Reference: **A38 Junctions Interested Party Statement from Derby Cycling Group**

We have reviewed the A38 Derby Junctions scheme in terms of its impact on existing active travel routes (ie those used for cycling and walking) and on its potential to create new and improved active travel routes and infrastructure. We see significant opportunities to gain huge benefits for **local** travel as well as for long distance through-journeys, especially by enabling more everyday journeys to be made by bicycle. However, **not enough regard is being taken of outcomes for cycle transport within the project's basic terms of reference.**

Designed	Drawn	Checked	Approved	Date
LB	TWS	GS	GS	04/03/19
Internal Project No.	Suitability			
60533462	S3			
Scale @ A1	Zone			
1:2500	A38/A5111 Kingsway

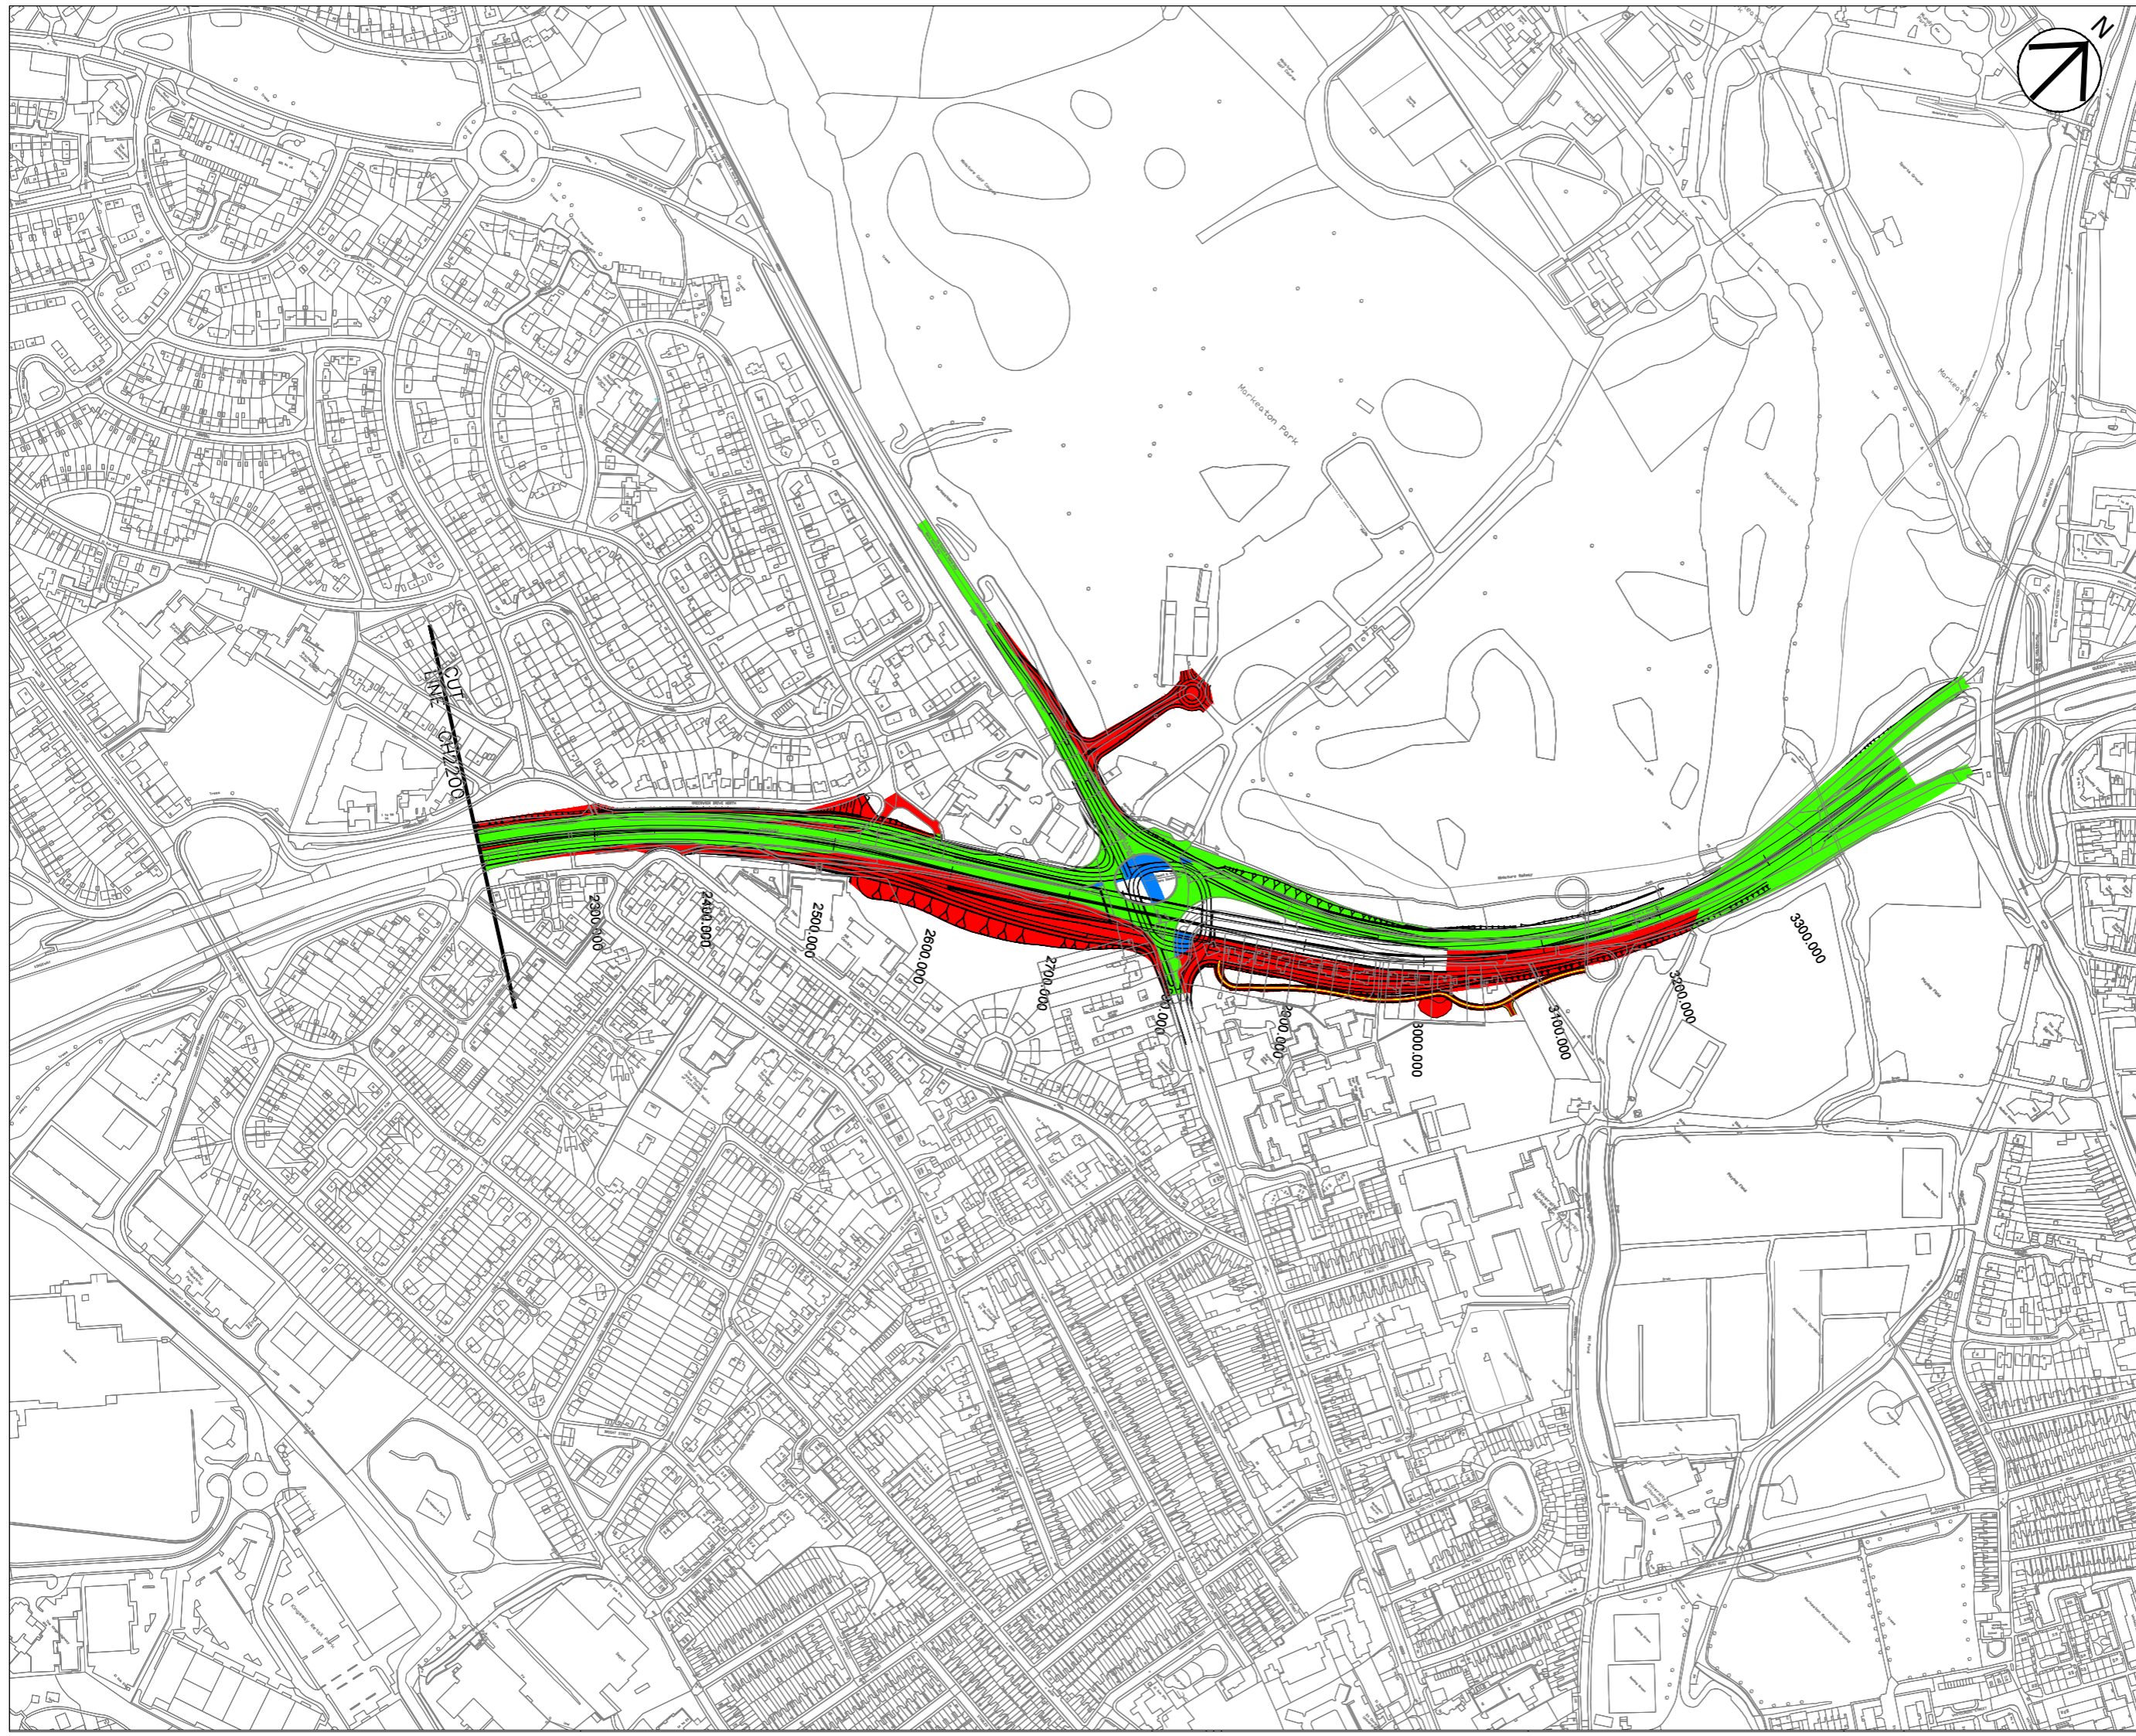
- Uncontrolled crossings over two lanes of traffic on slip roads at the Kingsway junction
- Discontinuous cycle routes and the lack of a controlled crossing on the A52 across the entrance to the Macdonalds/Esso garage site
- A significantly sub-standard route (ridiculously narrow) alongside the A38 between Little Eaton island and Ford Lane where it crosses the rail bridge.
- Lack of marked crossings over the Ford Lane exit from the Little Eaton junction and at the Starbucks entrance.
- A general reluctance to introduce segregation: pedestrian/cycle segregation should be the standard because these routes have the potential to become very well used, and indeed the A61 cycle path already is well used.
